From: Clare Dales
Sent: 23 January 2018 15:20
To: Simon Davis
Subject: RE: The Chapel, Flat 1 Barton Manor Barton Close Pagham PO21 4FH

On reviewing the proposals, I would recommend that the use of two rooflights as specified (rather than one roof light and one lantern), would be considered acceptable. The purpose is to illuminate a hallway and small room off this.

Proposed Ground Floor Plan

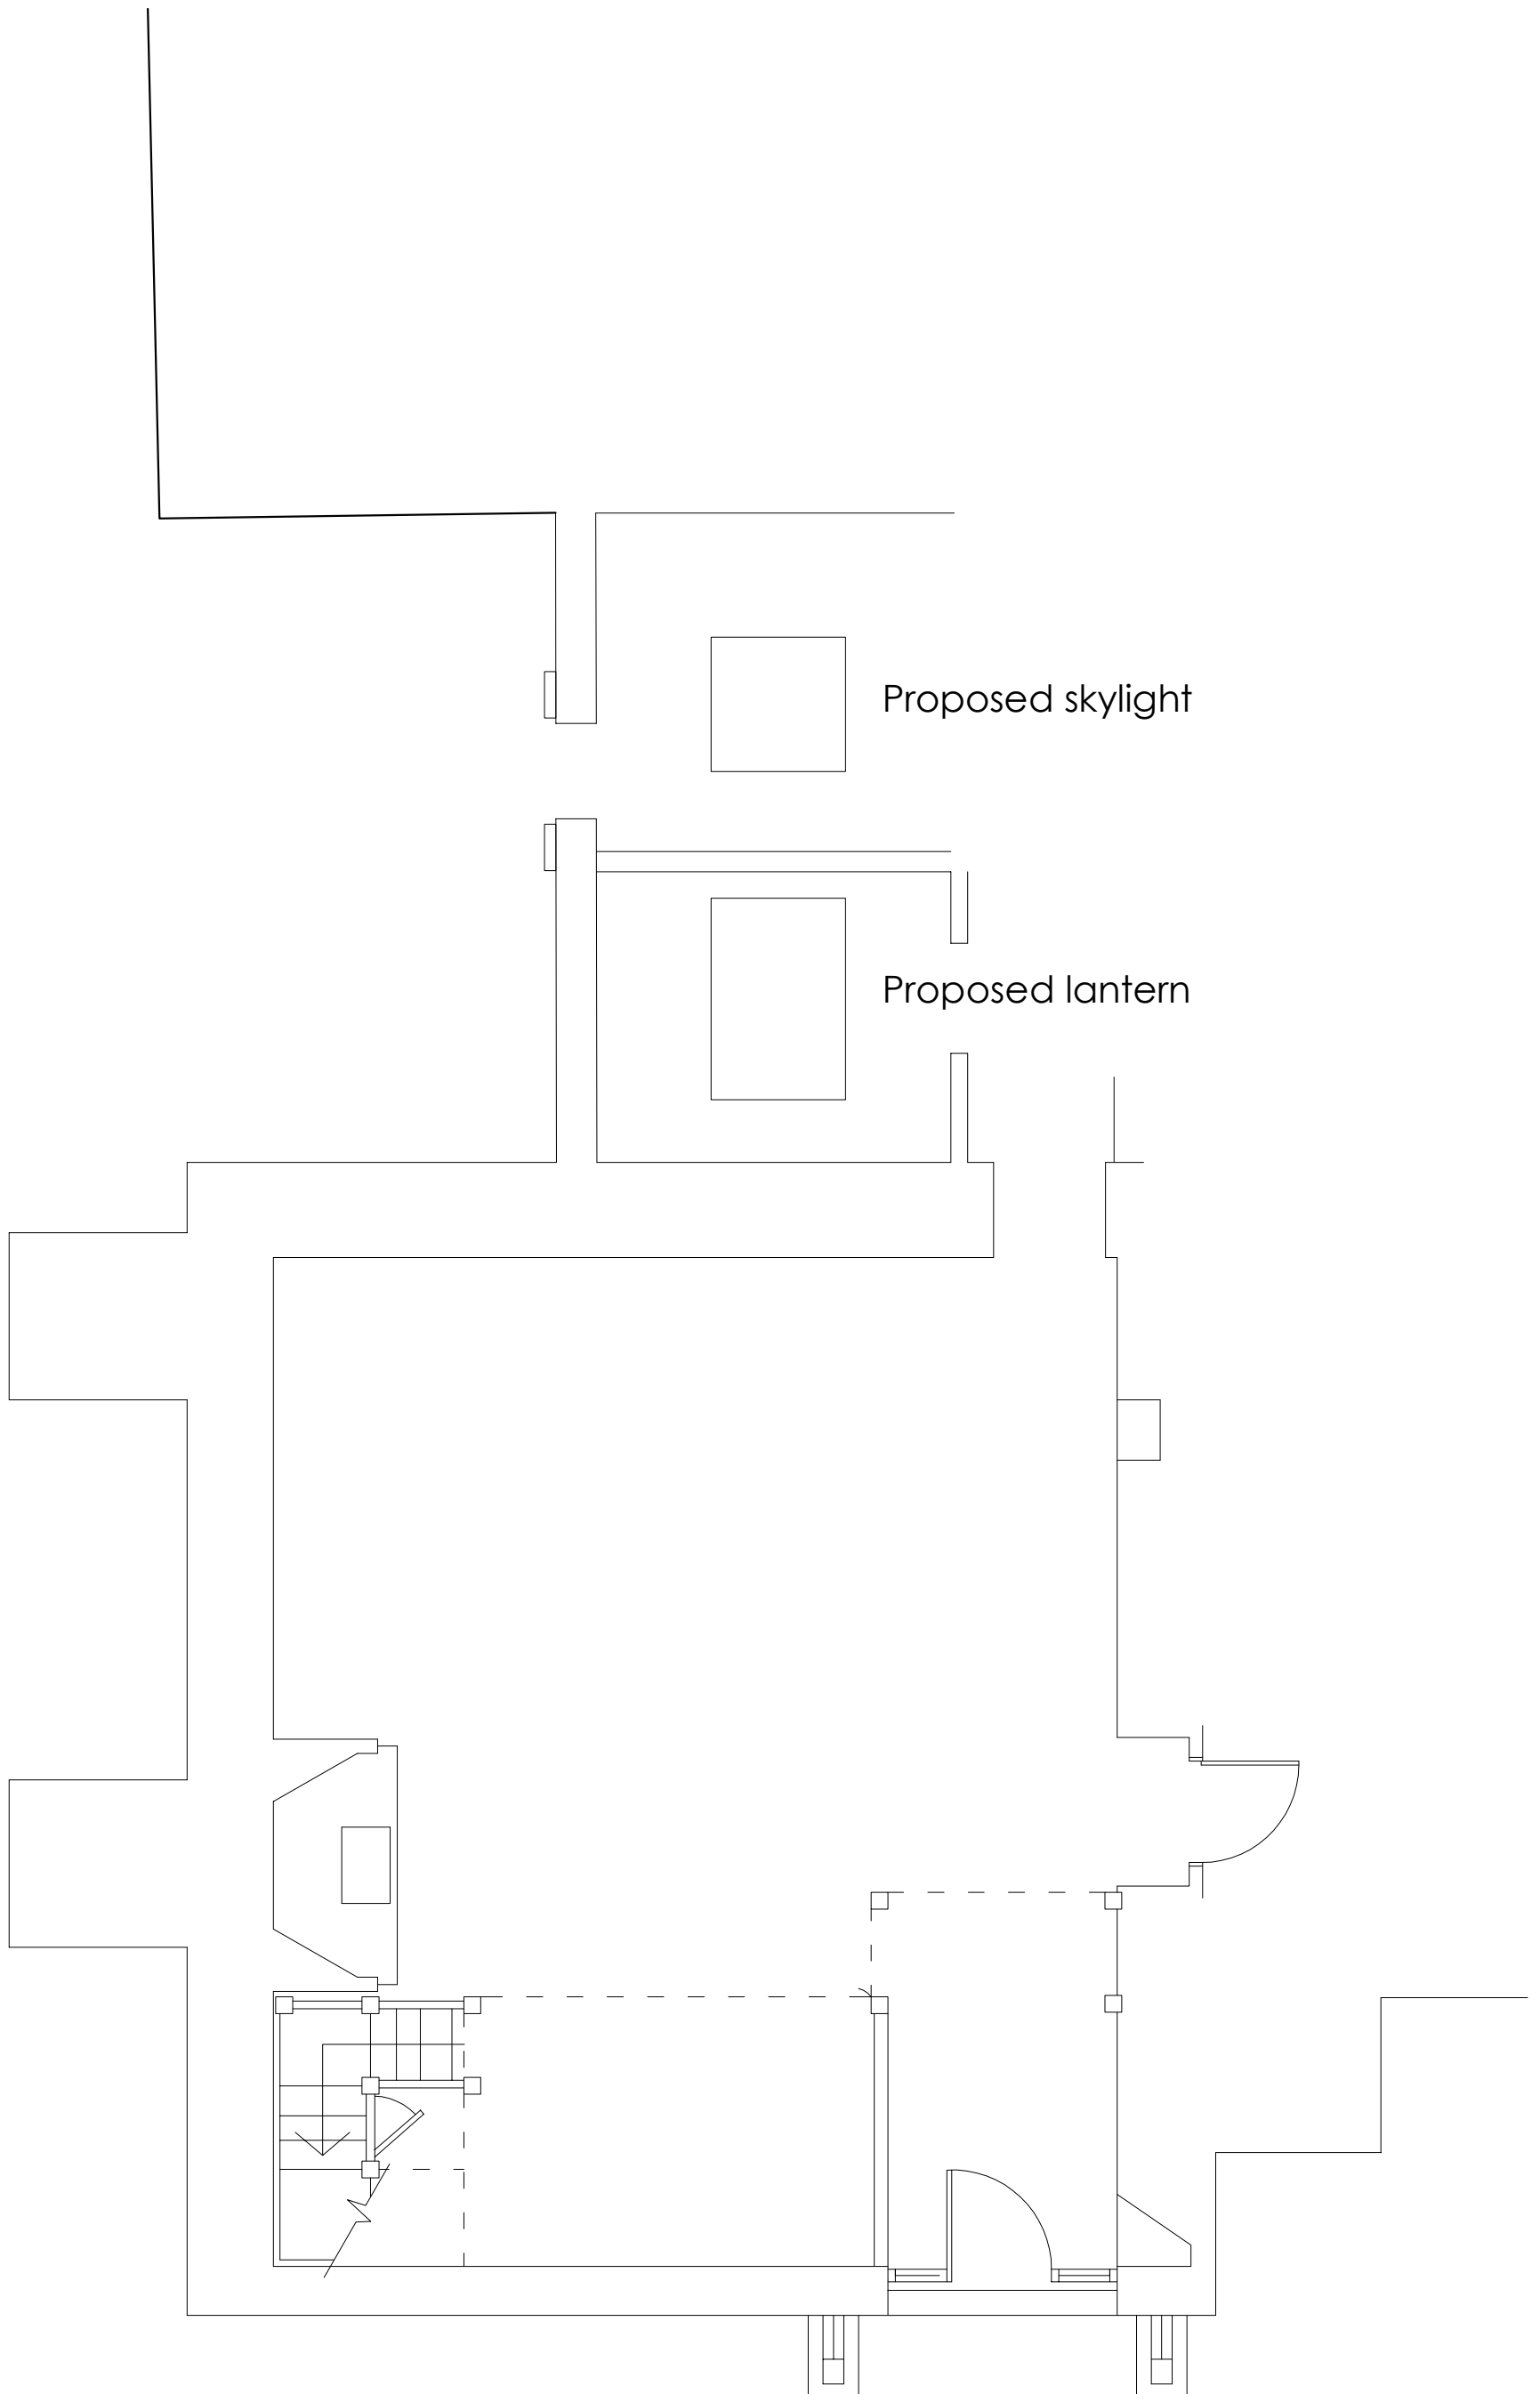
As the roofs are modern and does not harm the historic fabric, there is no objection other than that outlined above.
